## OFFICIAL NOTIFICATION OF DECISION

**Project# PR-2020-004447**  
**Application#**  
**SI-2021-01885 SITE PLAN**

For all or a portion of:  
**TRACT A-1, SUNPORT MUNICIPAL ADDITION**  
zoned **NR-SU**, located at **2200 SUNPORT BLVD**  
**SE between UNIVERSITY BLVD SE and YALE**  
**BLVD SE** containing approximately 20.88  
acre(s). (M-15)

PNM PUBLIC SERVICE COMPANY OF NEW MEXICO	
PROJECT SITE PLAN	
SAGEBRUSH SUBSTATION	
DR:	DATE: 10/29/21
CKD:	OK:
APP:	SCALE: As Noted
REV. NO.	SBD-7602-S2 2 OF 7

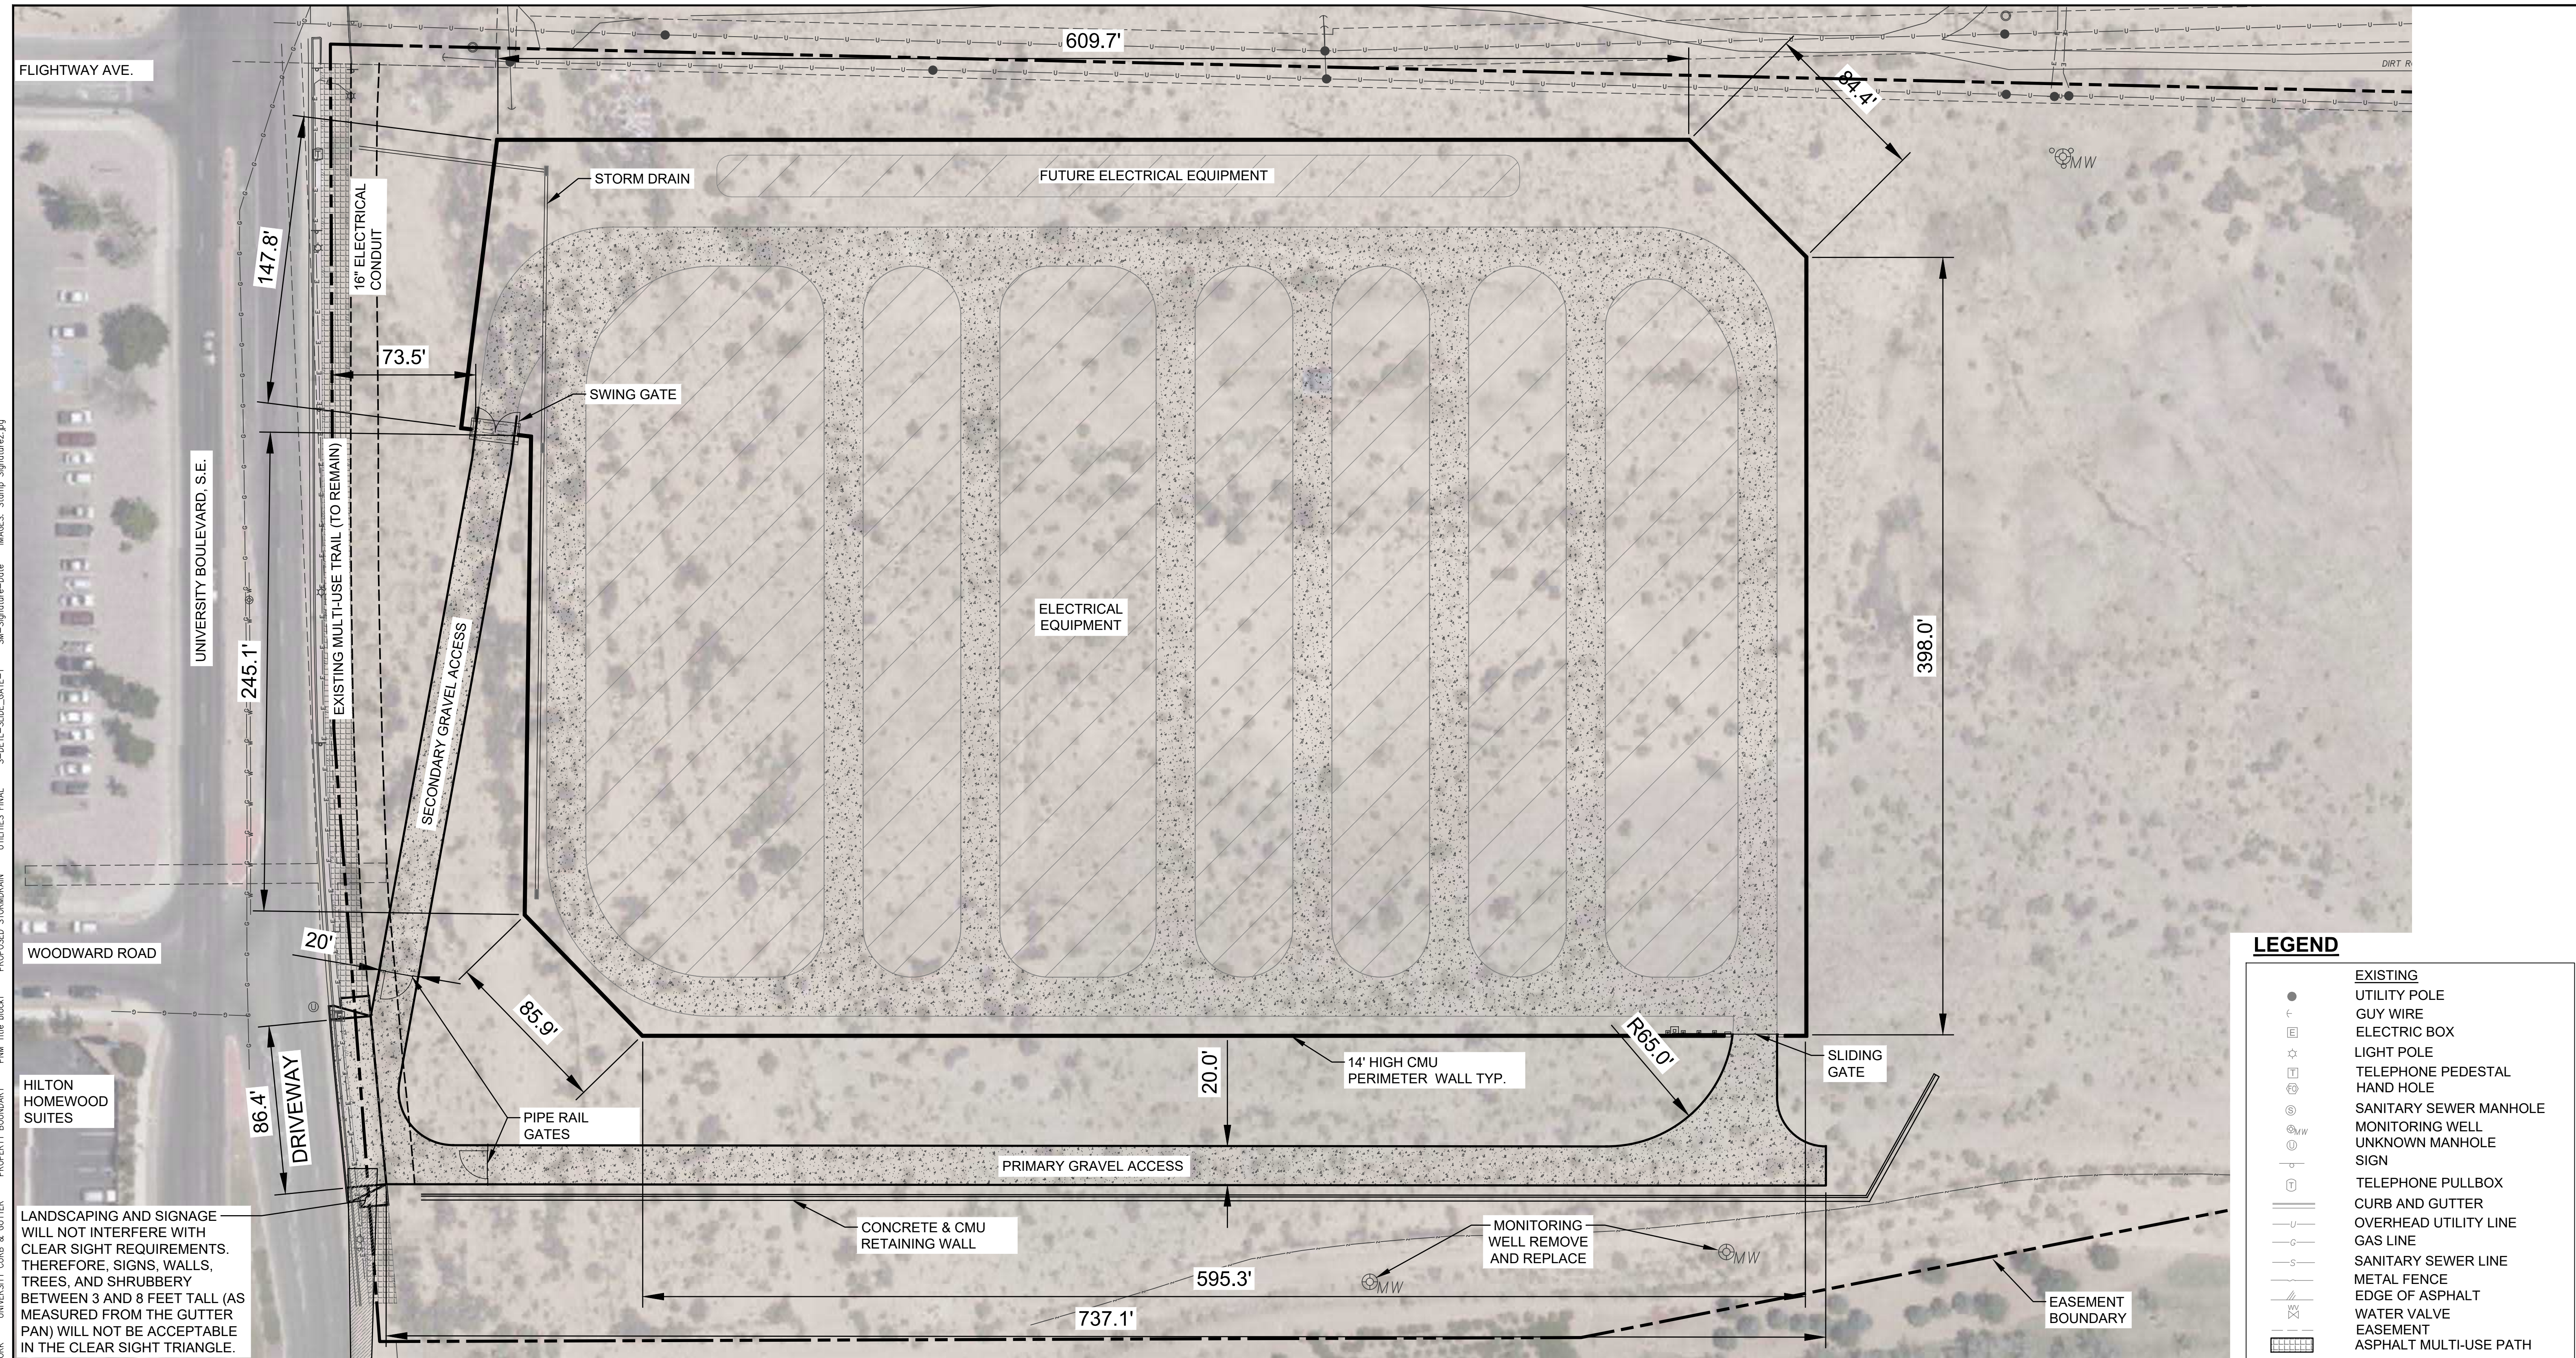
3. Final sign off is delegated to Planning for a signature block for DRB and Environmental Health signatures; Environmental Health signature; project and application numbers to be added to the Site Plan; Alternative Landscape Plan approval; turnarounds to be provided in front of the University Boulevard gates; minor notes for the driveway detail as discussed at the December 8, 2021 hearing; add a landscape note to require a minimum of 5-feet of clearance from the trail to any plant material; submit PNM property easement to the City of Albuquerque Parks and Recreation Department (PRD) for review and possible update to allow for PRD access to the trail for maintenance into perpetuity; and for the Site Plan sheets to be signed and sealed by a licensed design professional.

DR:	DATE: 02/01/21
CKD:	OK:
APP:	SCALE: As Noted
REV. NO.	SBD-7602-S6 6 OF 7

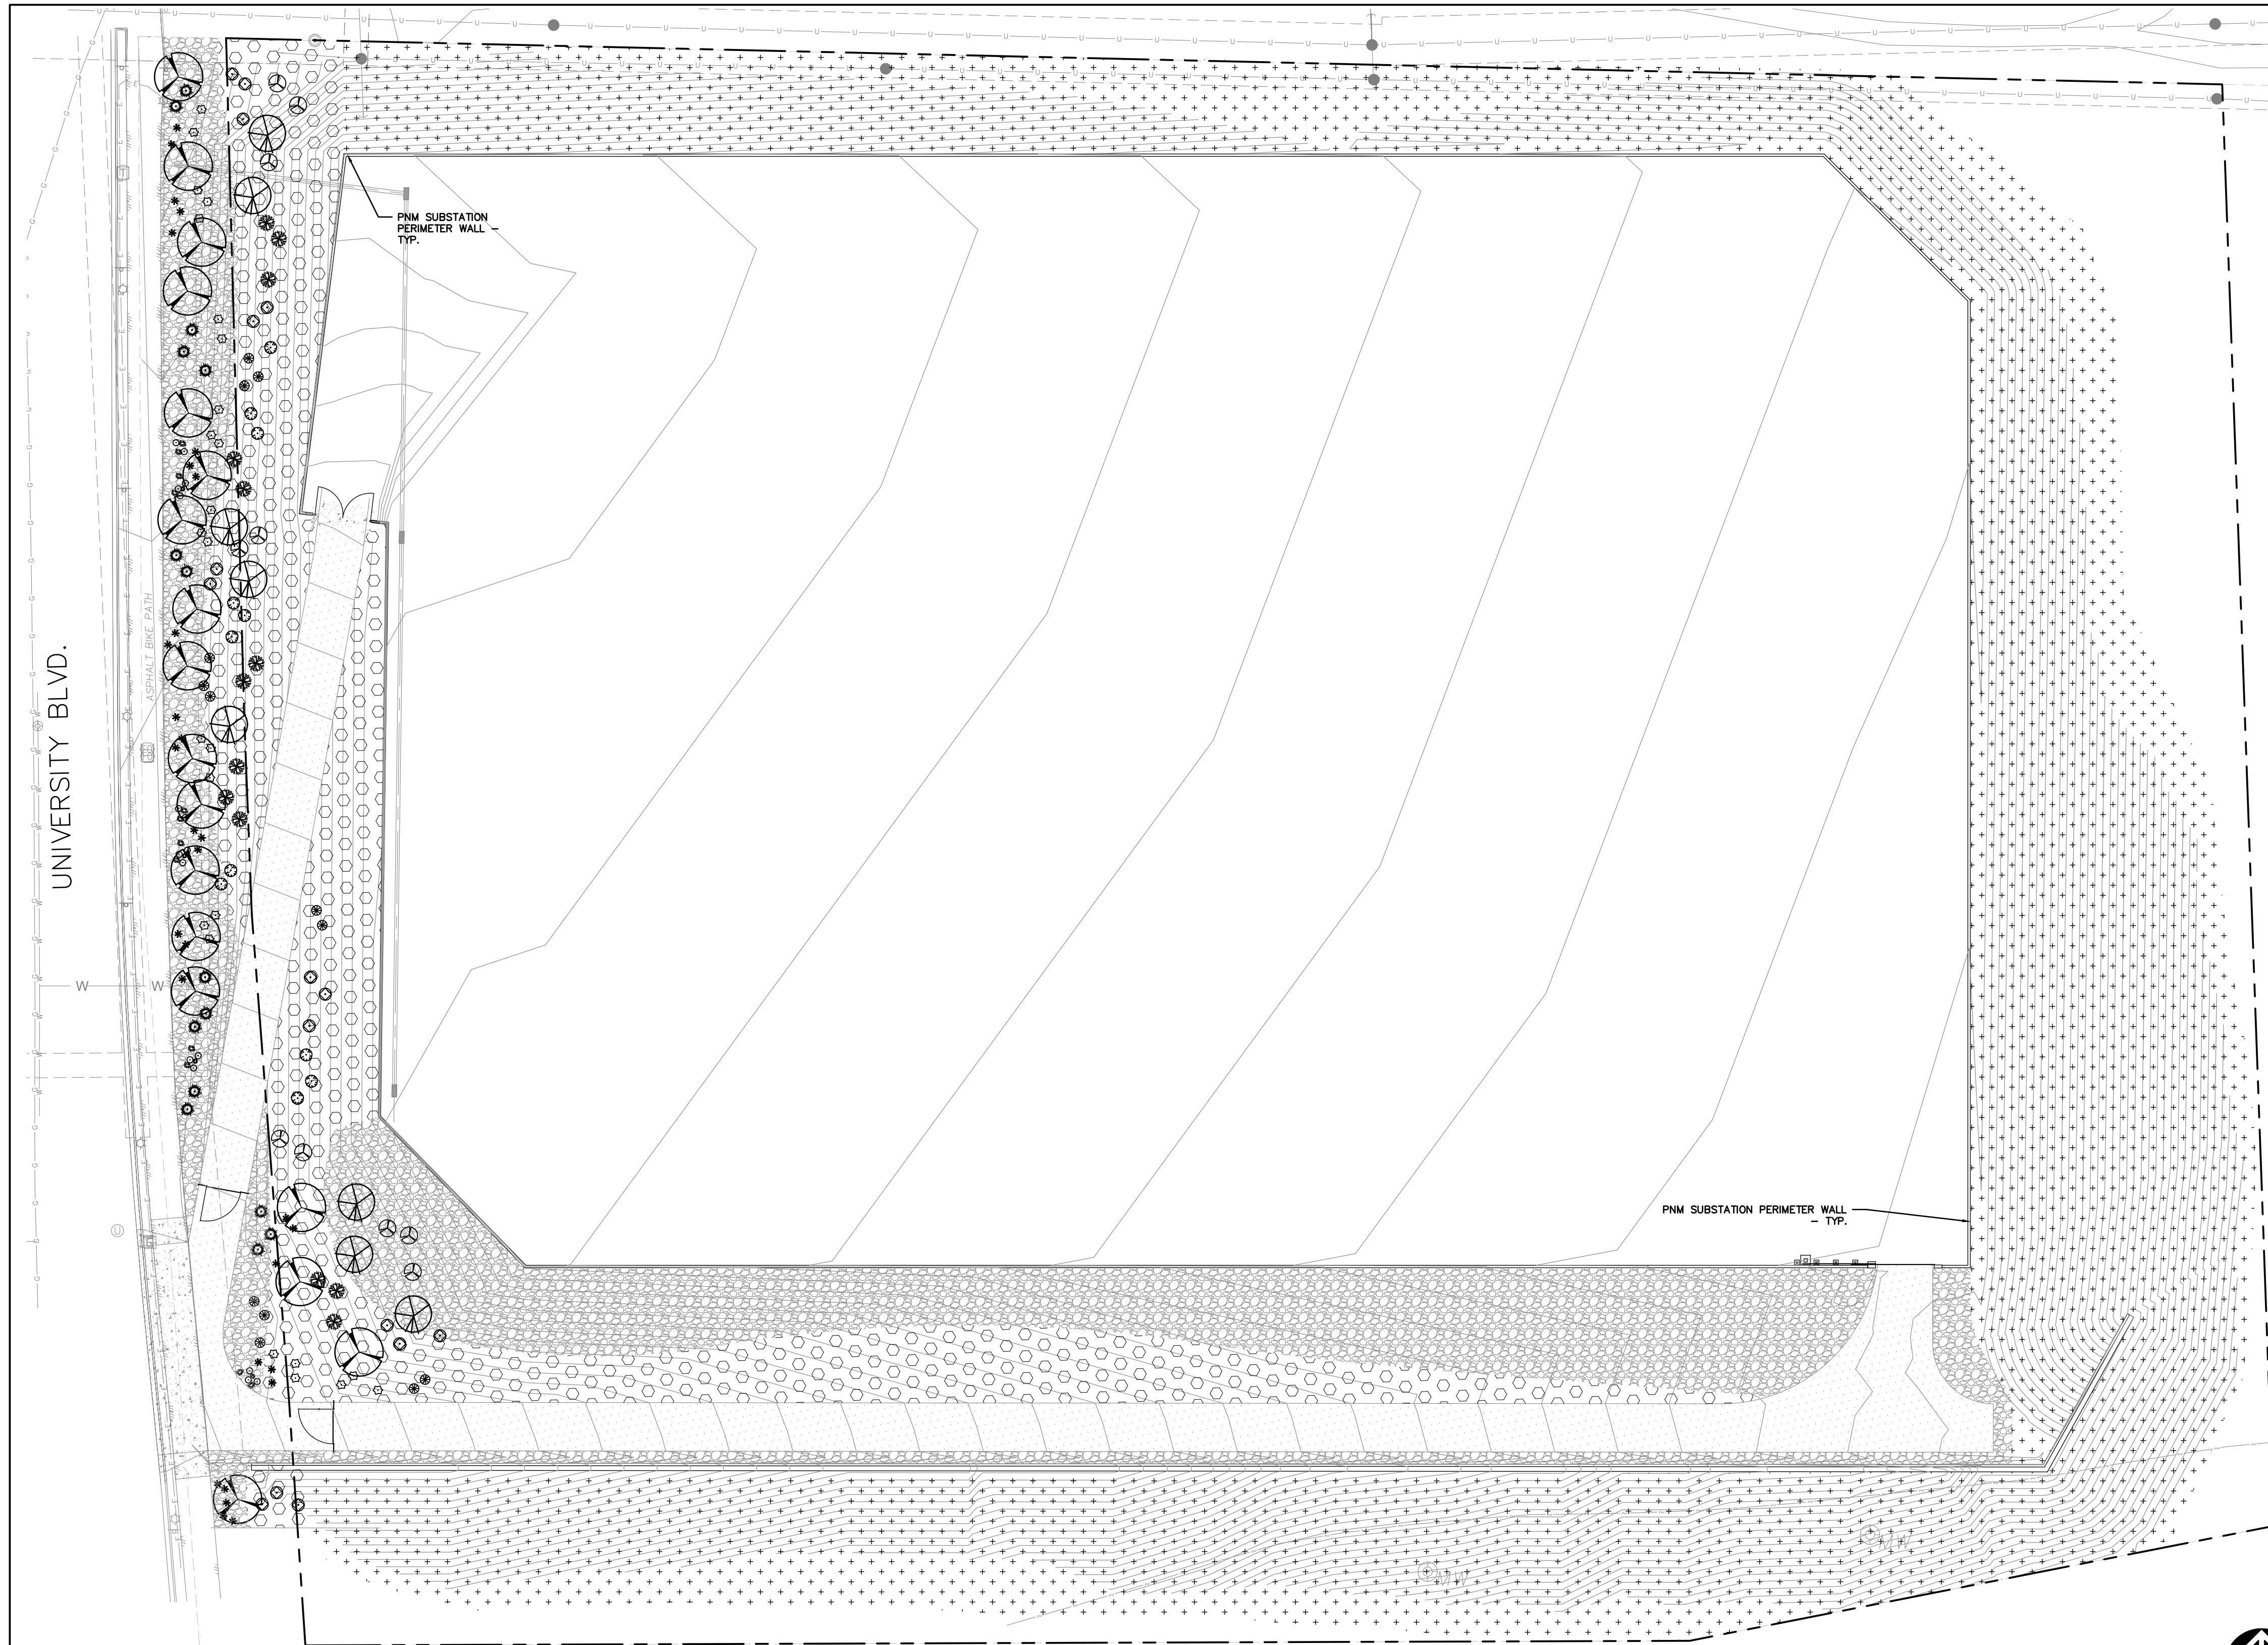
The proposed development complies with all applicable provisions of the IDO and DPM with the exception of the landscaping, buffering, and screening requirements of 5-6 of the IDO. An Alternative Landscape Plan will be required to be approved administratively by City staff which is consistent with the purposes of 5-6 of the IDO; the Alternative Landscape Plan must not include a reduction of tree planting requirements;

the Alternative Landscape Plan must provide equal or superior buffering of adjacent properties from anticipated impacts of the proposed development; the Alternative Landscape Plan must provide equal or superior visual appearance of the property when viewed from the street; and the Alternative Landscape Plan must provide equal or superior carbon dioxide absorption and heat island reductions.
